City of Albuquerque

May 19, 2003

**Re: John Blair Project Site Plan submitted for Traffic Circulation Layout
1500 3rd St. NW
Architect's Stamp dated 4-23-03, (J14/D135)**

A-0

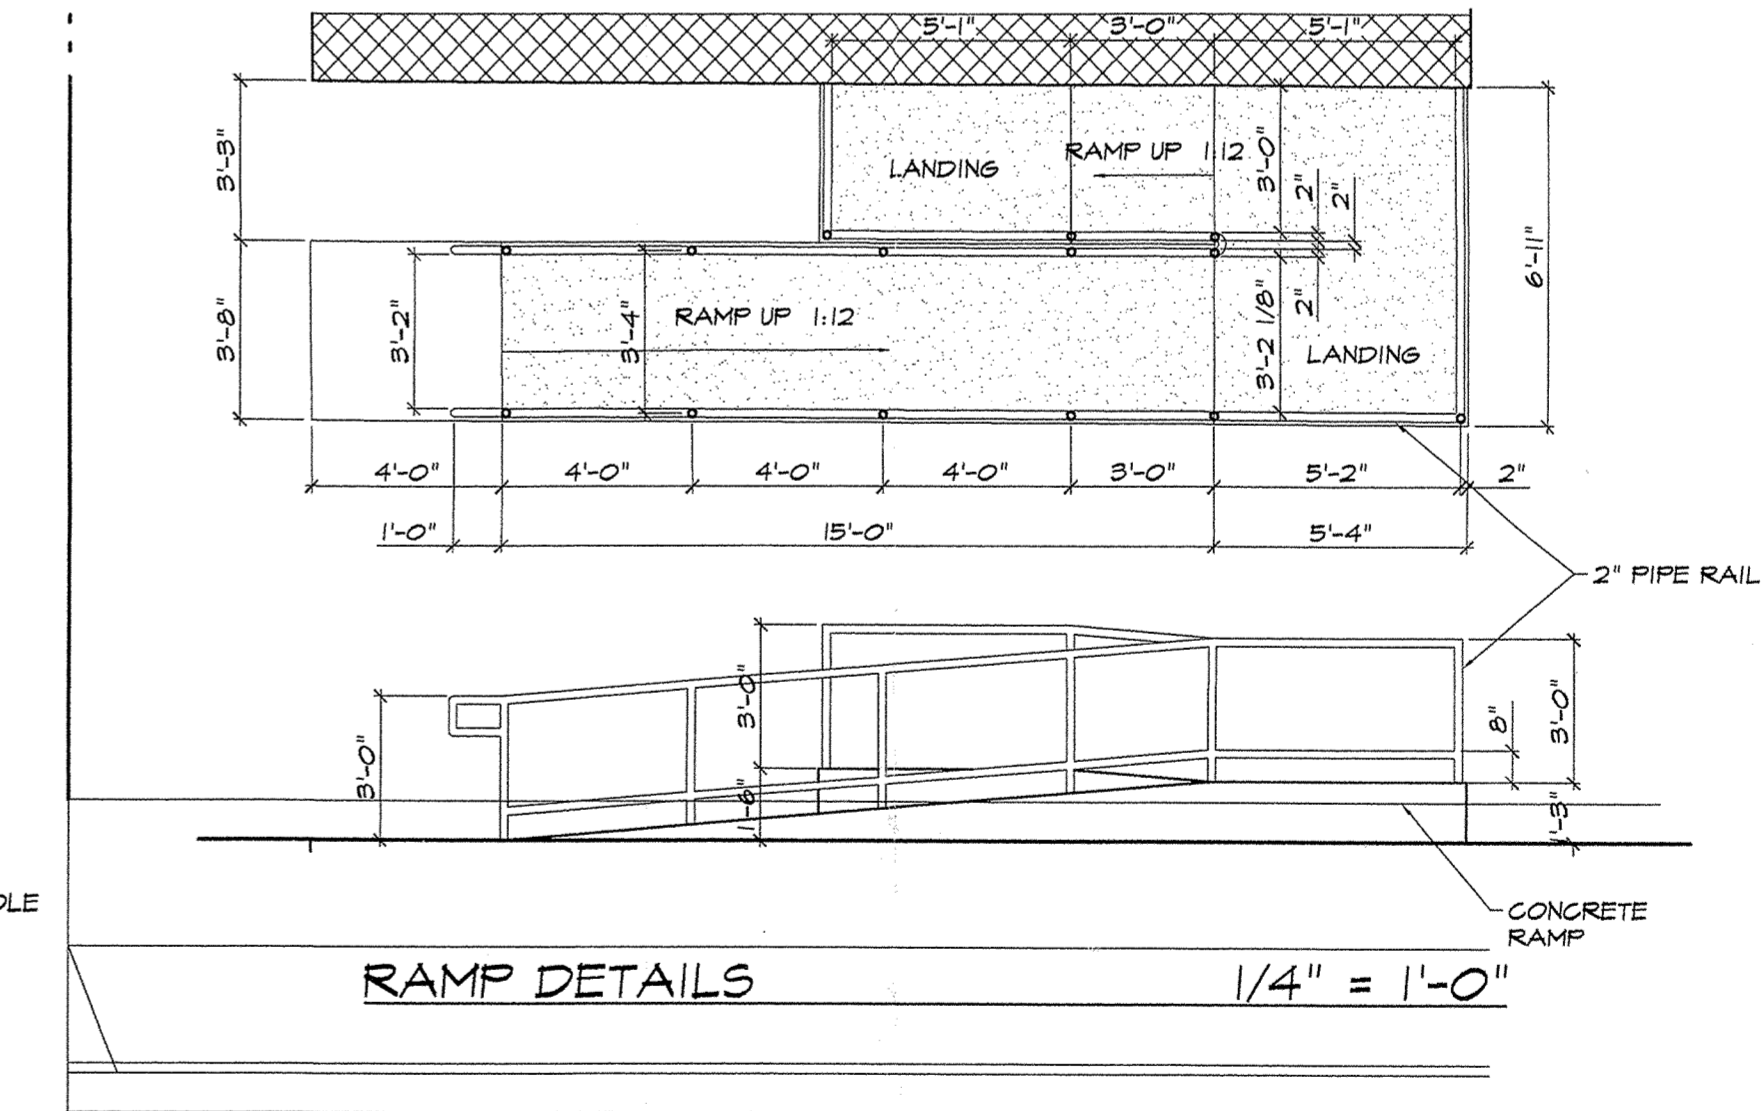
- A lot consolidation replat or cross access and parking easements must be submitted prior to Building Permit approval.
- The driveway on Constitution should be a maximum of 30' wide.
- Please denote that the northernmost parking spaces are for employees only.
- Please denote type of delivery vehicle expected and add turning templates to the plan.
